From: [REDACTED]
To: [Norfolk Boreas](#)
Subject: Norfolk Boreas: Oulton Parish Council's submission at Deadline 2. Ref: 20022619
Date: 09 December 2019 22:30:26
Attachments: [BOREAS-Oulton PC Written Questions at D2.docx](#)
[D7 Oulton Parish Council Orsted HOW3.pdf](#)
[Oulton AD Appeal DECISION.pdf](#)

OULTON PARISH COUNCIL: PINS Ref: 20022619

Oulton Parish Council's response to Written Questions for Norfolk Boreas Scenarios 1 & 2 at Deadline 2

DRAWING No.
TP-PB4476-DR033

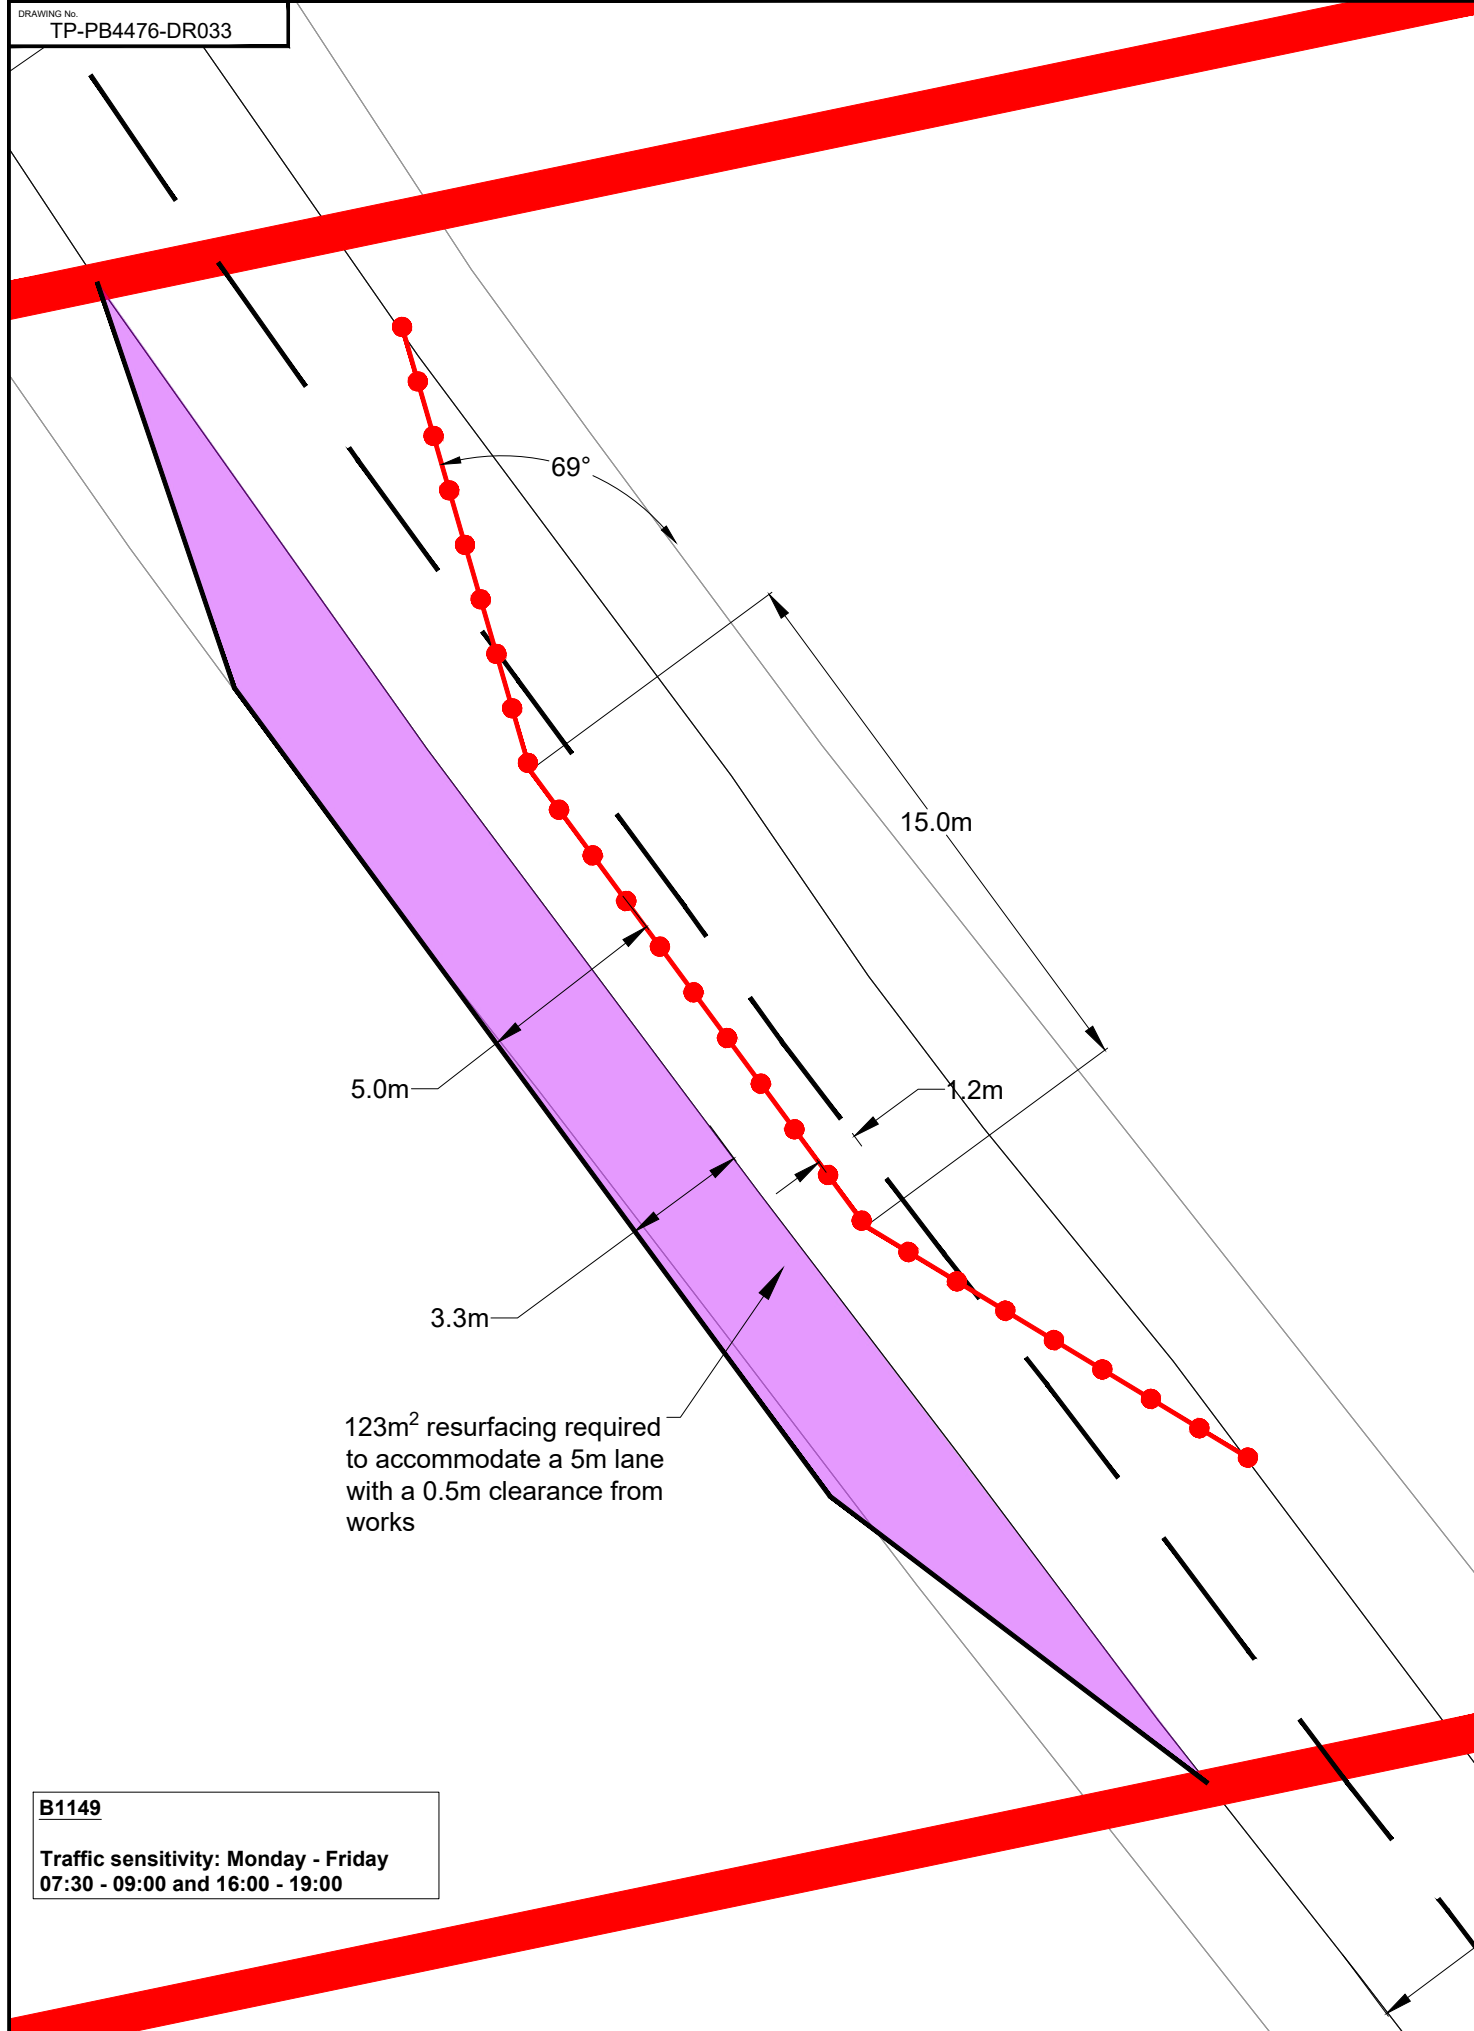
It is noted that there have been changes to the proposed road works to the trenching on B1149. These changes appear in the Applicant's Outline Traffic Management Plan appendices (version 2) submitted at Deadline 1. There are changes to the width and length and M3 required for resurfacing the area; these differ from the plans as submitted at Deadline 8 for the Norfolk Vanguard DCO.

OPC queries whether this would mean the need to use more of the verge to produce the increased road width, and if so, is this land secured within the DCO?

OPC also queries whether these revised plans have been accepted by Norfolk County Council, given their negative response at deadline 9 of the Norfolk Vanguard examination?

Is the separation between the B1149 junction with The Street and the proposed road works (205m) sufficient? Has the Applicant also taken into consideration the cumulative impact of Norfolk Boreas Scenario 2 with Equinor's Dudgeon and Sheringham Extension project, if they were to be constructed during the same time period? The cable corridor for the latter will pass extremely close to this trenched crossing.
